HINCKLEY NATIONAL RAIL FREIGHT INTERCHANGE

Response to Deadline 1: Written Representations

Leicestershire County Council

October 2023

Figure 3.9: Area of Influence

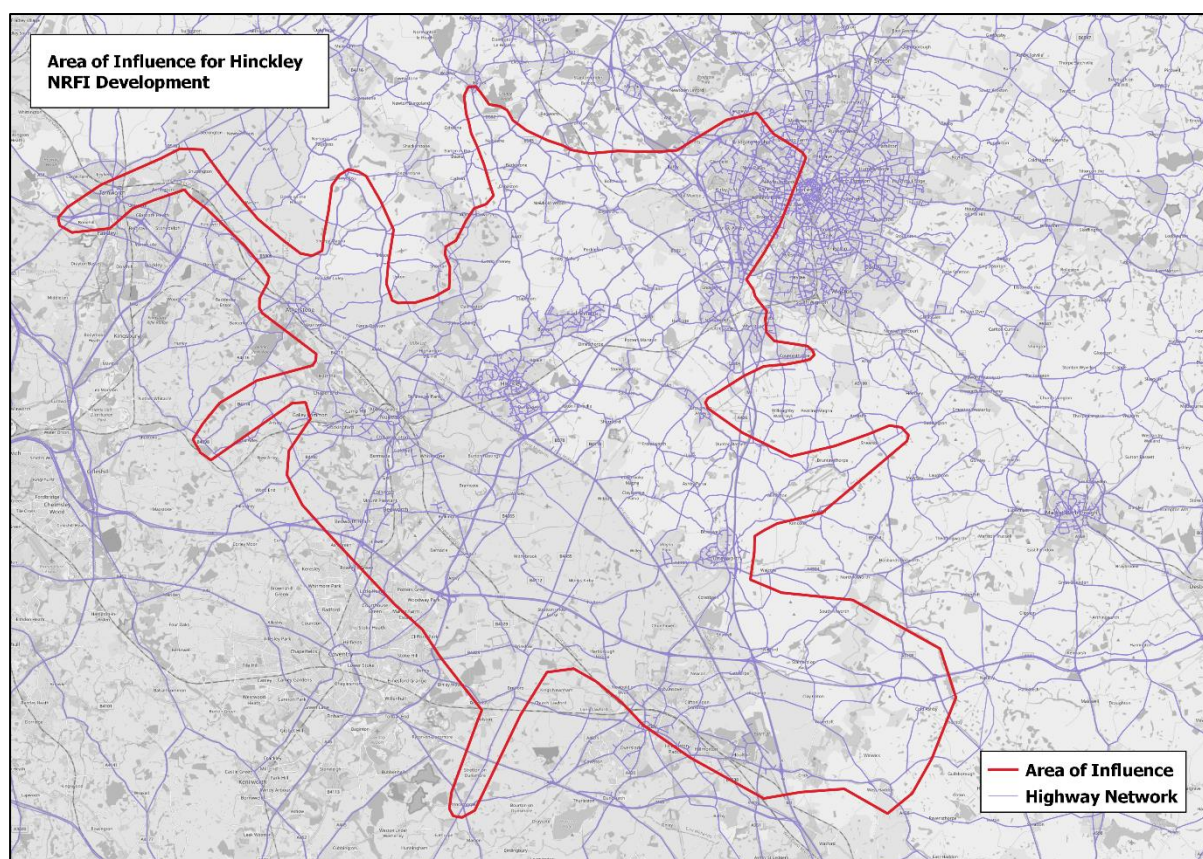
- 2.38 However, the Collision History Study area at Figure 4-10 of the submitted Transport Assessment (*APP-138*) was not agreed with the HAs, nor does it marry with the Area of Influence (Aol) of the development as identified in the Forecast Modelling (*APP-148*). The Collision History Study area should be expanded to reflect the area of impact of the development i.e., the agreed Aol.

2036 'With Development (Sensitivity Test)' (AM)

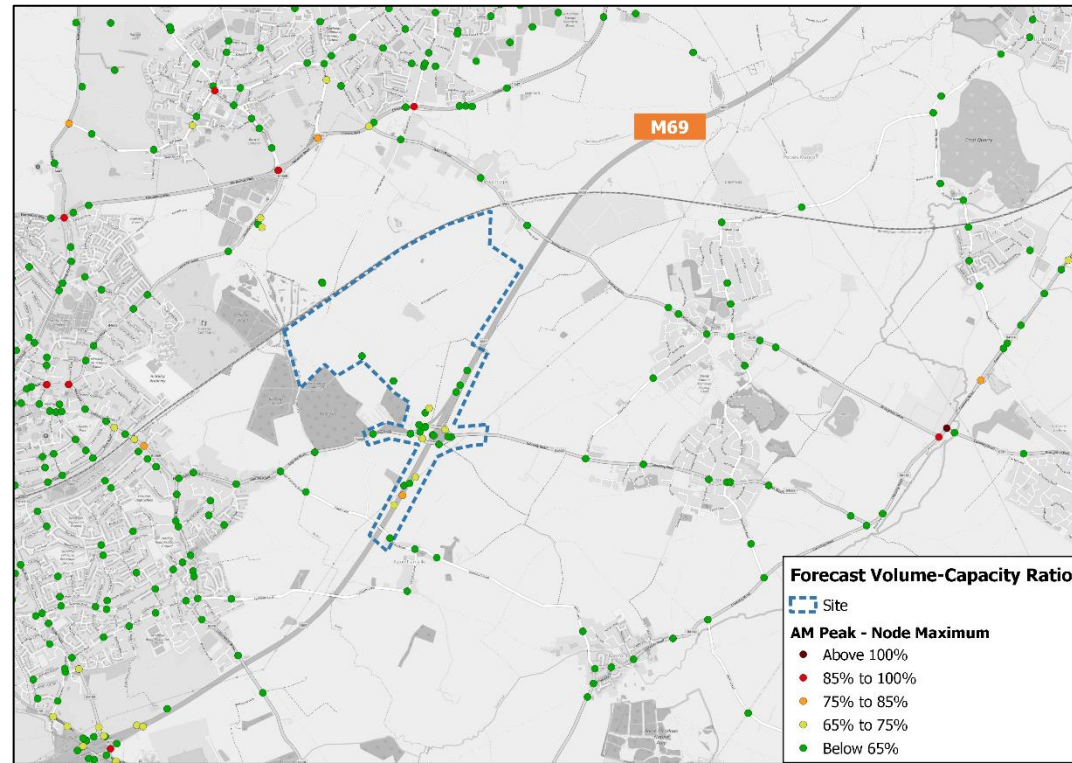
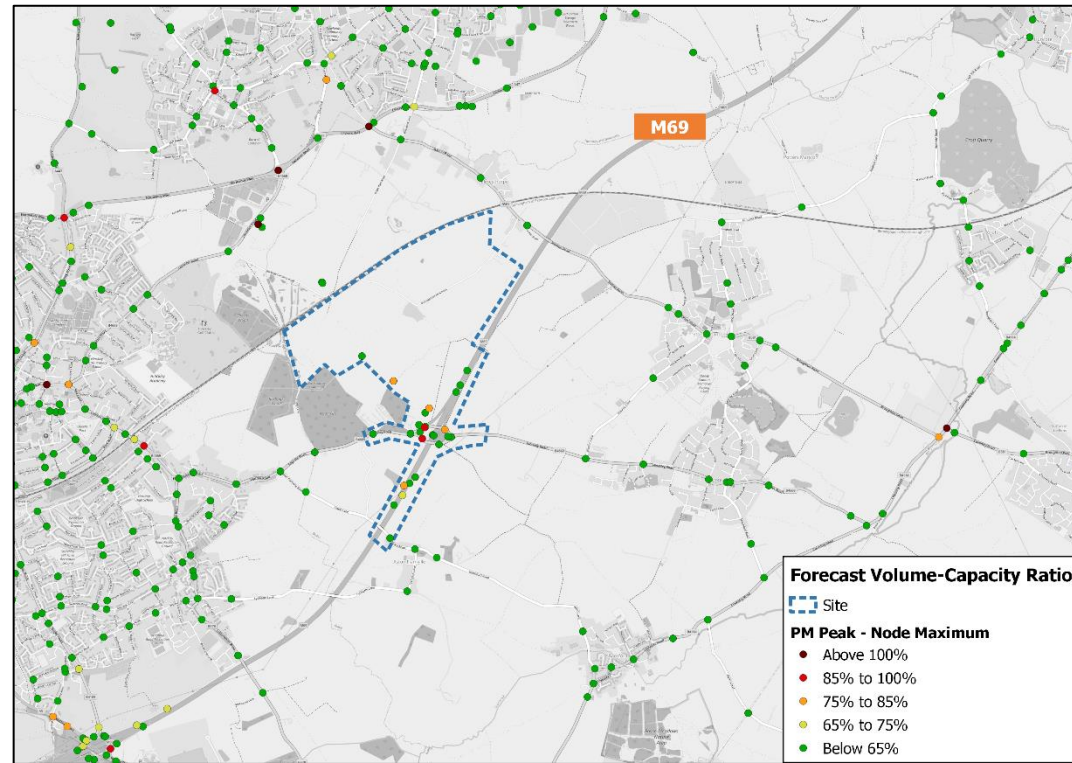
2.30 It can be seen from the submitted drawings that the A47 link road is proposed to be dual carriageway from its junction with M69 J2, to its junction with the third roundabout, and then single carriageway thereafter to the B4668 Leicester Road. The TWG agreed that a sensitivity test of the A47 link road dualled along its entire length should be carried out. This was included in section 5: Model scenarios of the agreed Forecast Modelling Brief (*APP-145*). It is noted that the results of this modelling exercise have not been reported in the submitted Transport Assessment (*APP-138*). Therefore, LCC LHA is unable to conclude if the

development access infrastructure would operate within capacity and with a reduced impact on the wider network if dualled in its entirety. Modelling outputs previously provided to LCC LHA suggest that this could be the case.

Written Statement of Oral Case ISH6 [Appendix C – Plan for A47 link road footway/cycleway design]

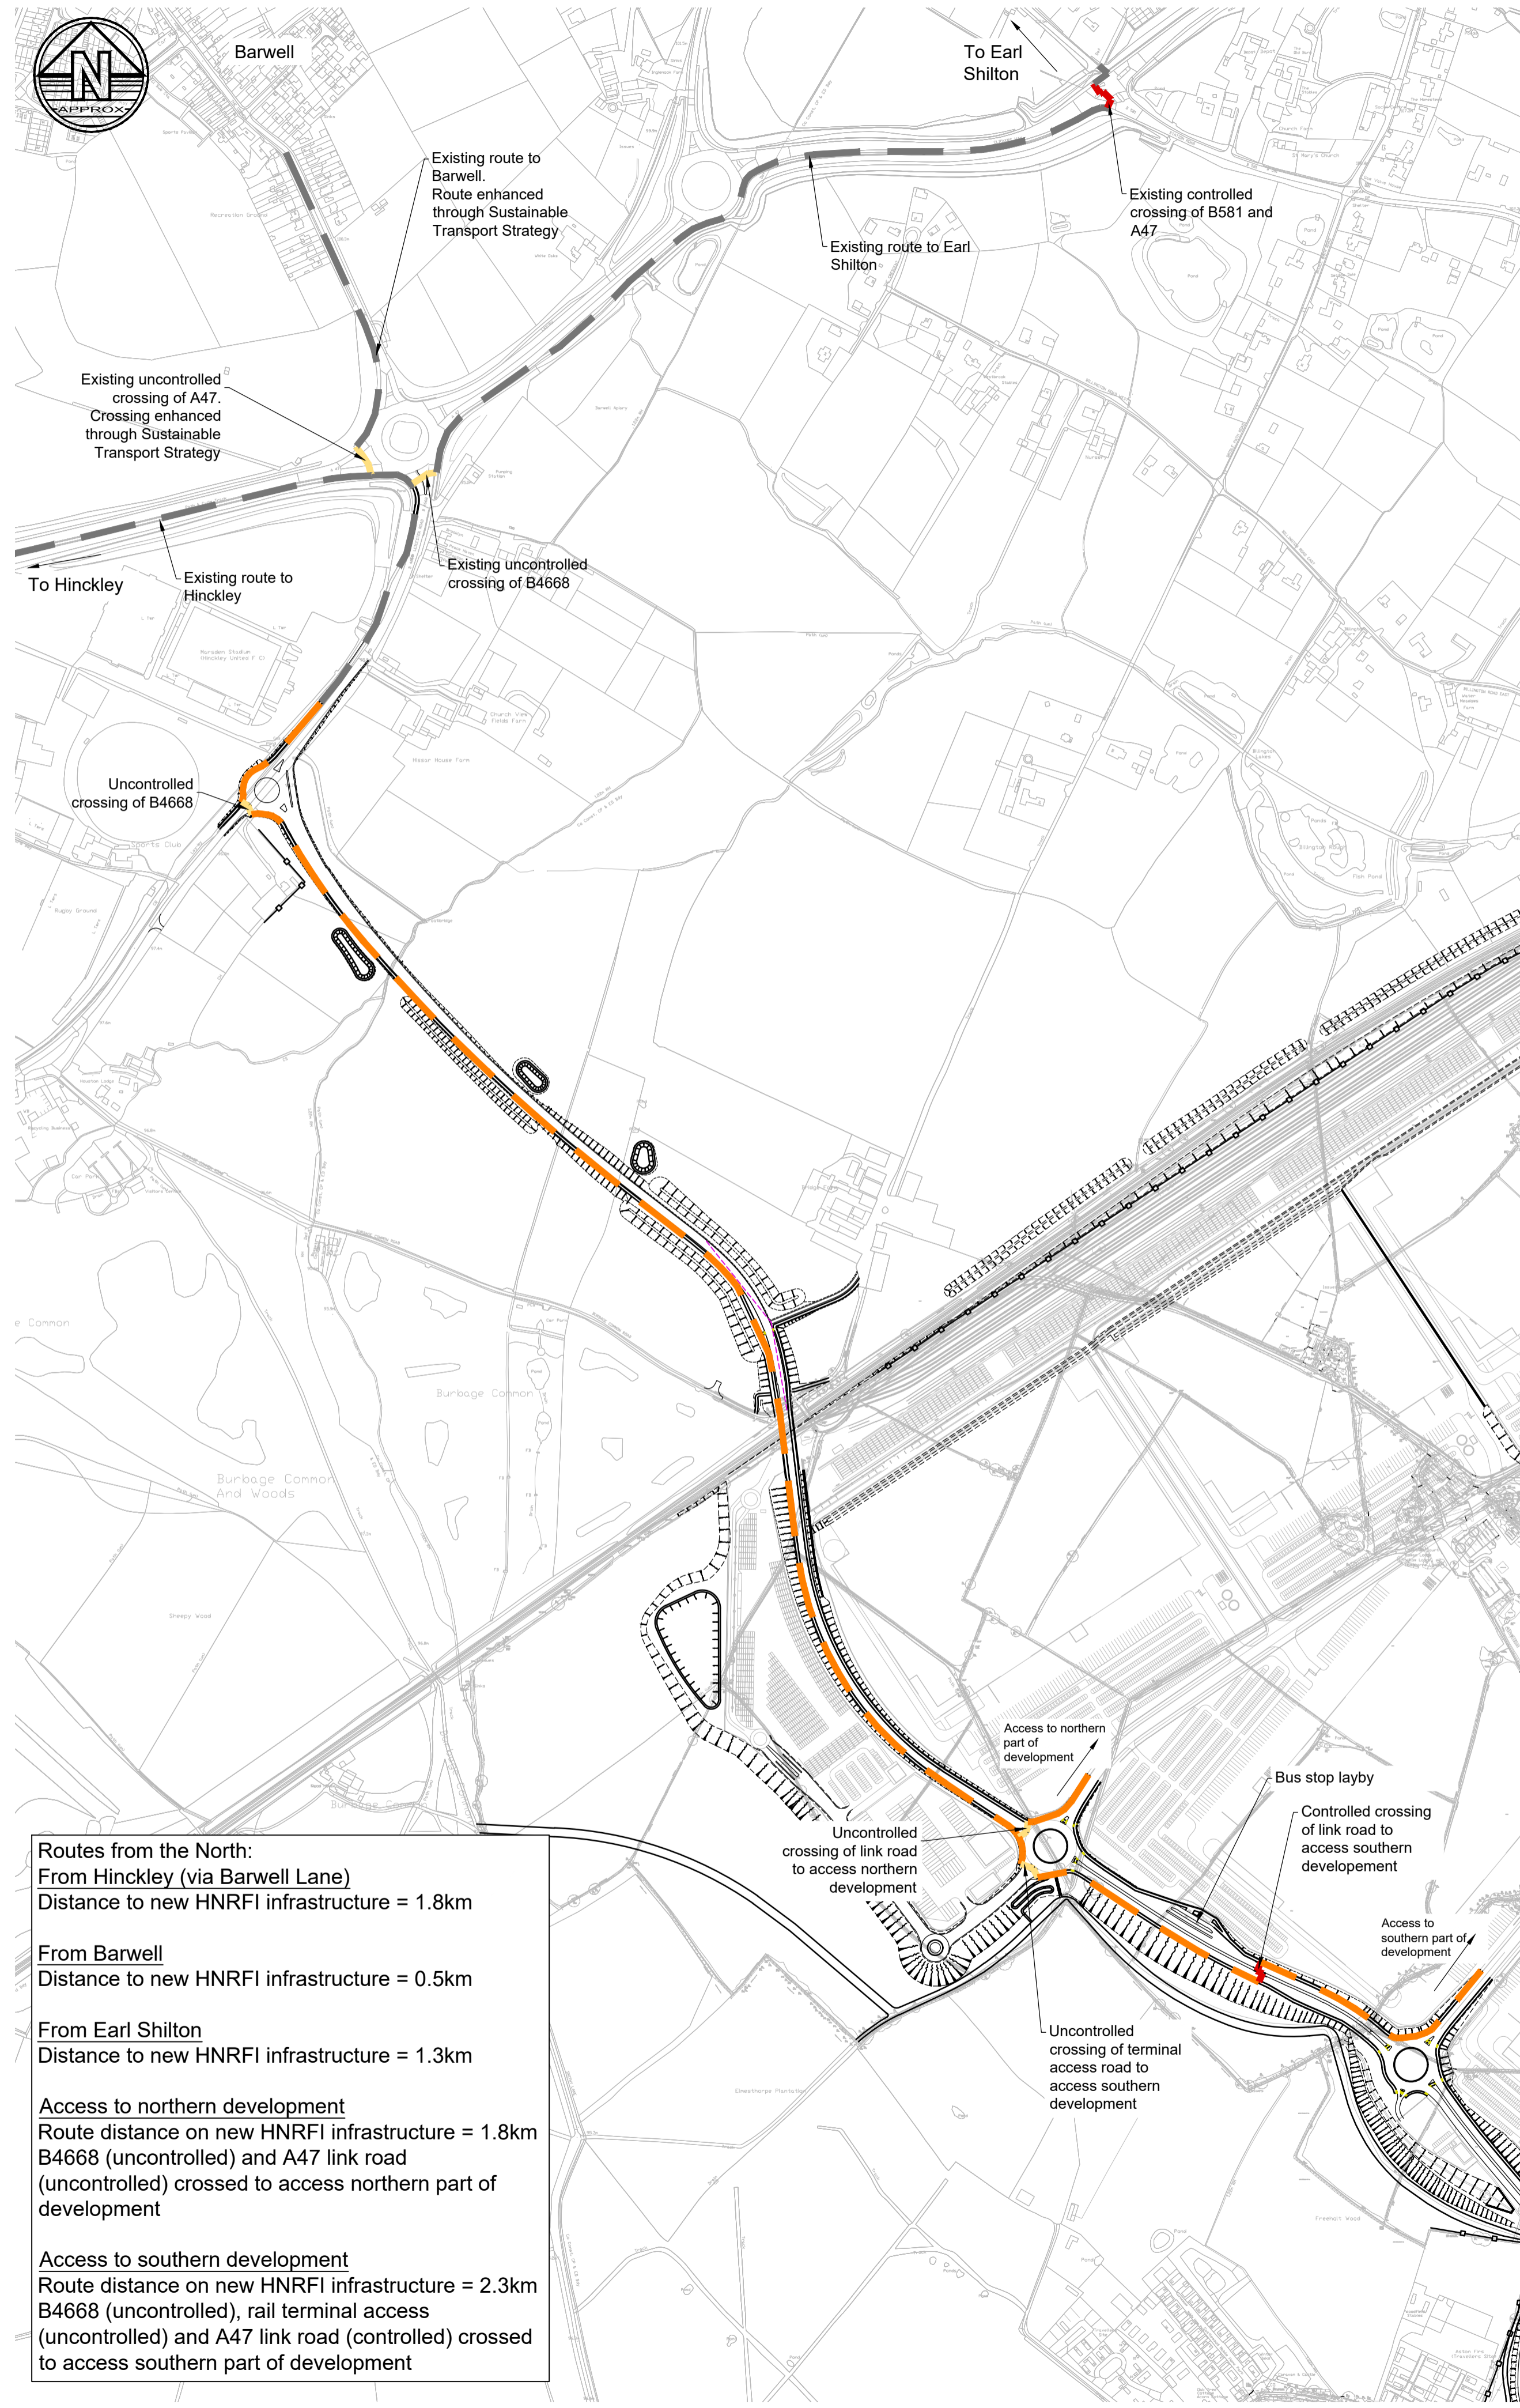
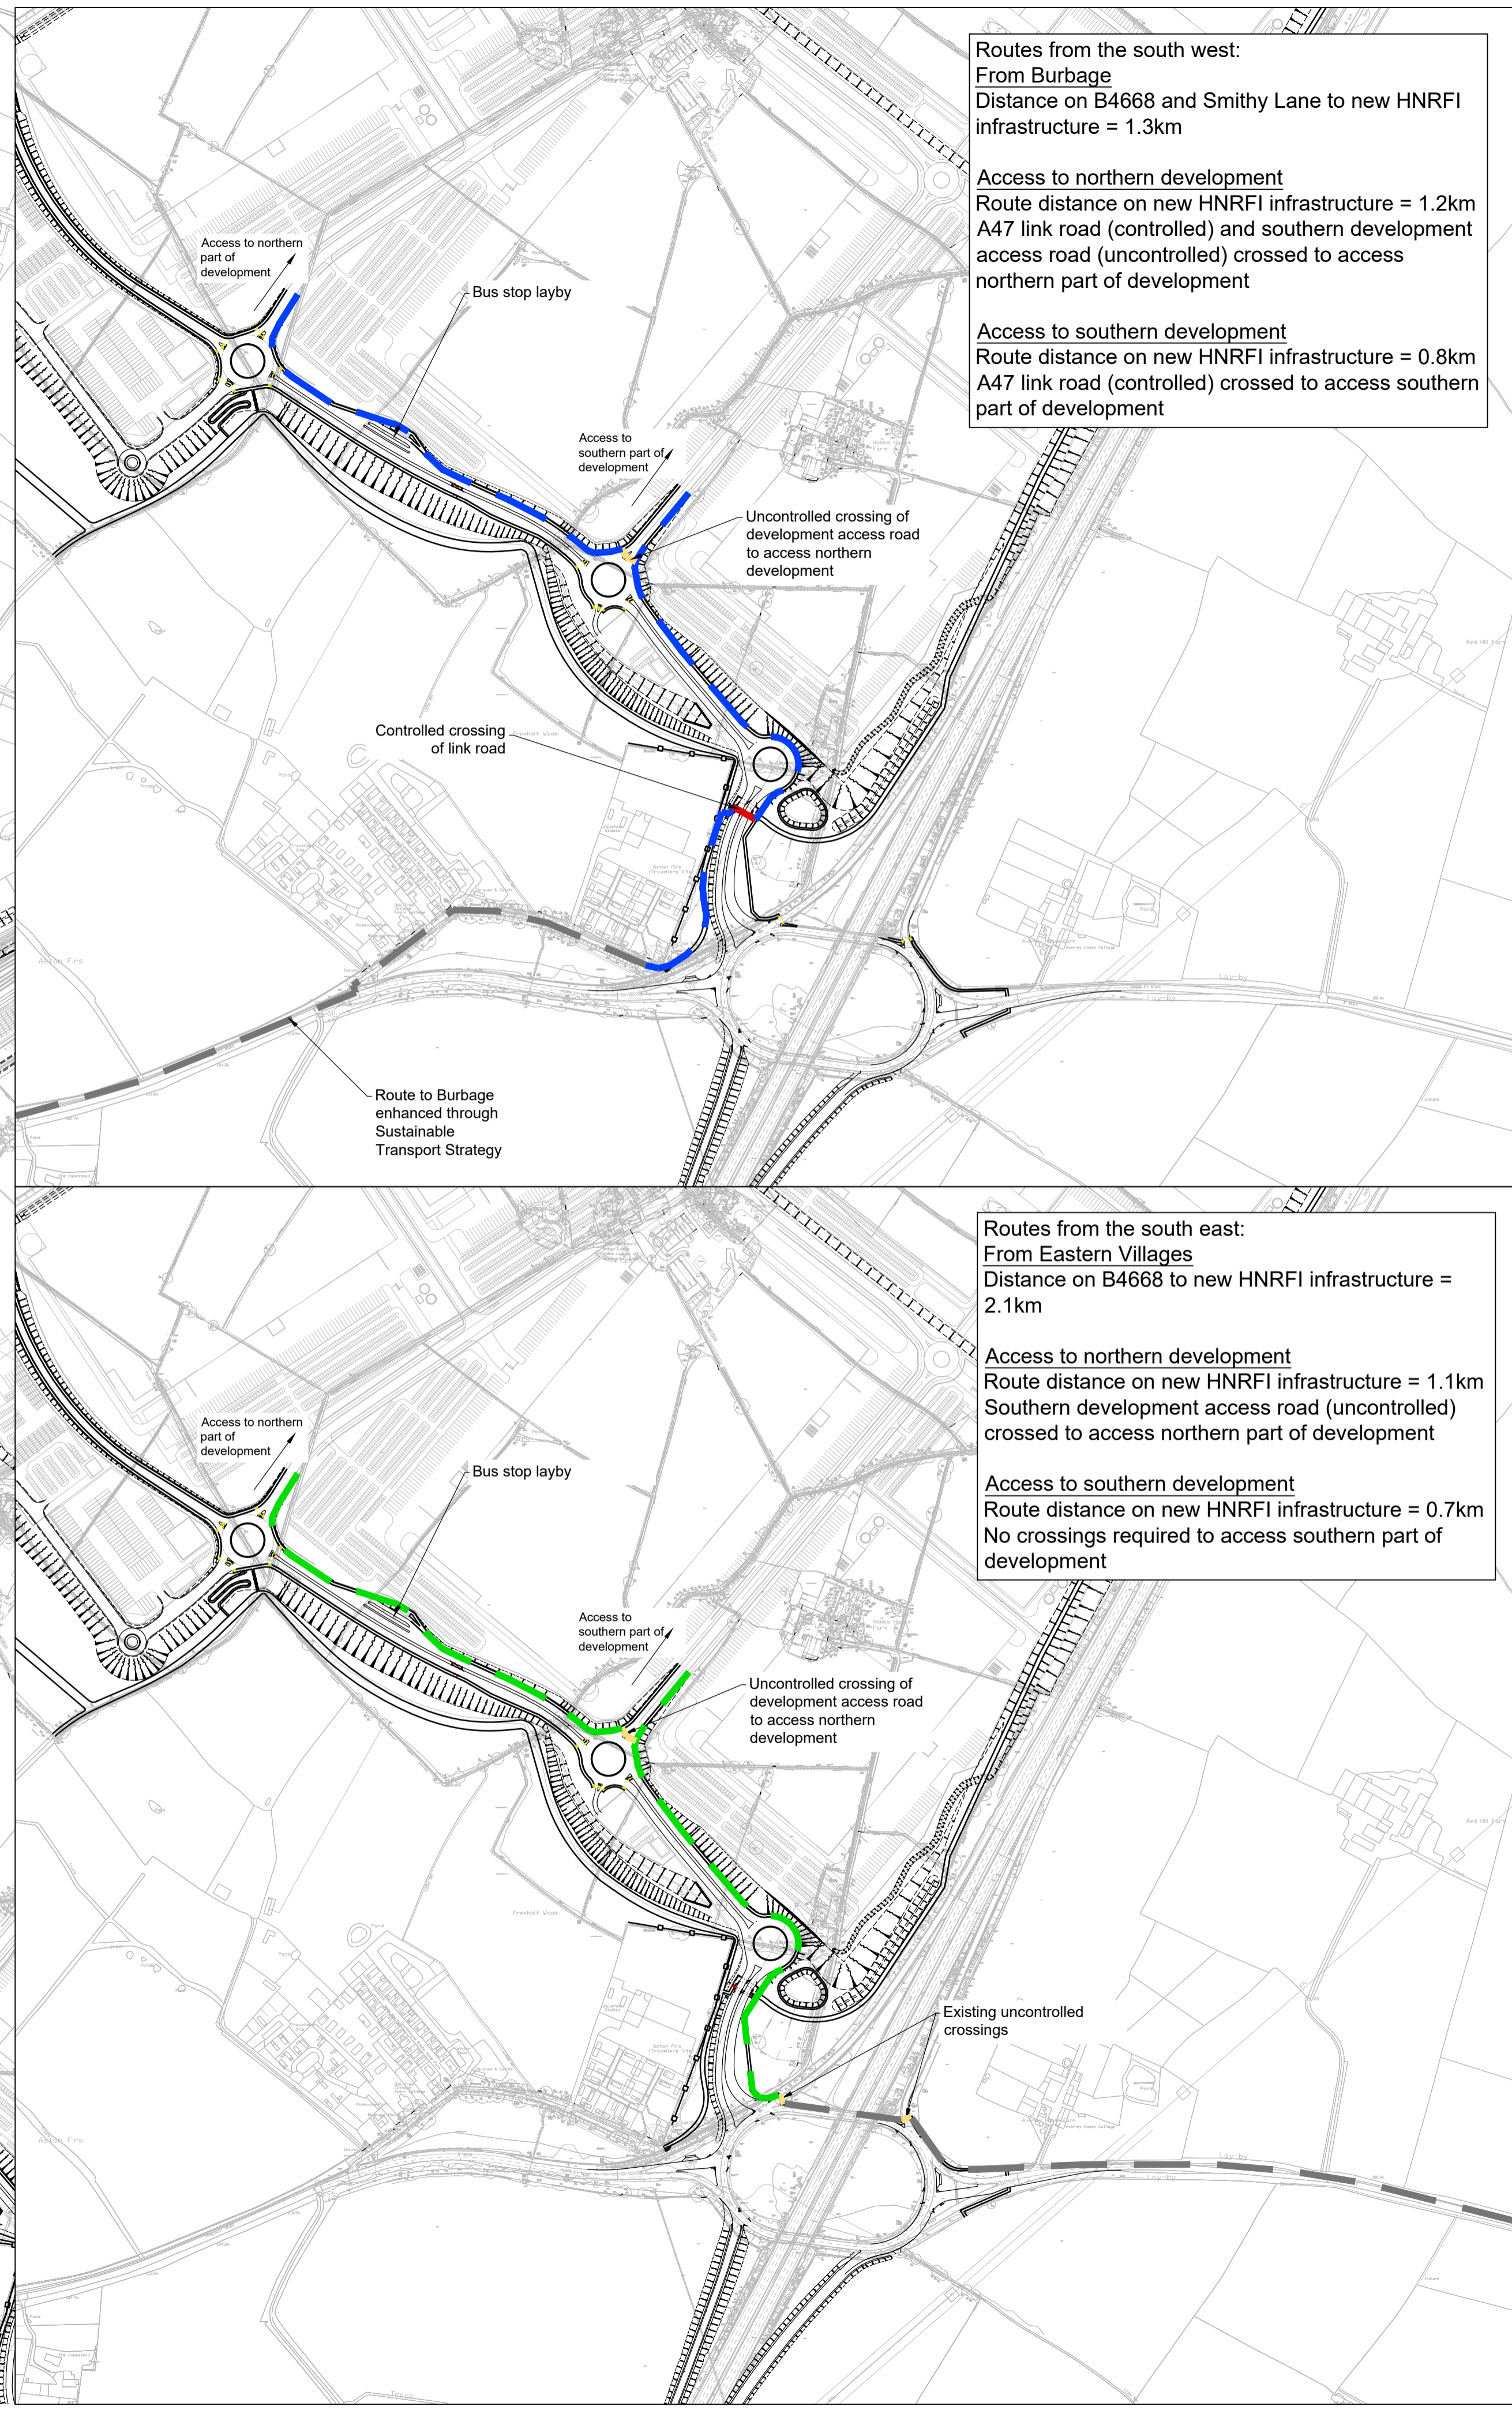
- 2.32 From the scale of the drawings submitted it appears that the link road includes for a 3m footway/cycleway which does not appear to be continuous and would require pedestrians and cyclists to continually cross the road, not always with designated crossing provision. *APP-011* does appear to include for a pegasus crossing and a toucan crossing. However, it remains unclear how these facilities link with footway/cycleway provision. The drawing does not include for connections to existing provision on the B4668 Leicester Road, creating gaps in pedestrian and cycle provision for employees drawn from the villages of Barwell, Earl Shilton and Elmesthorpe.
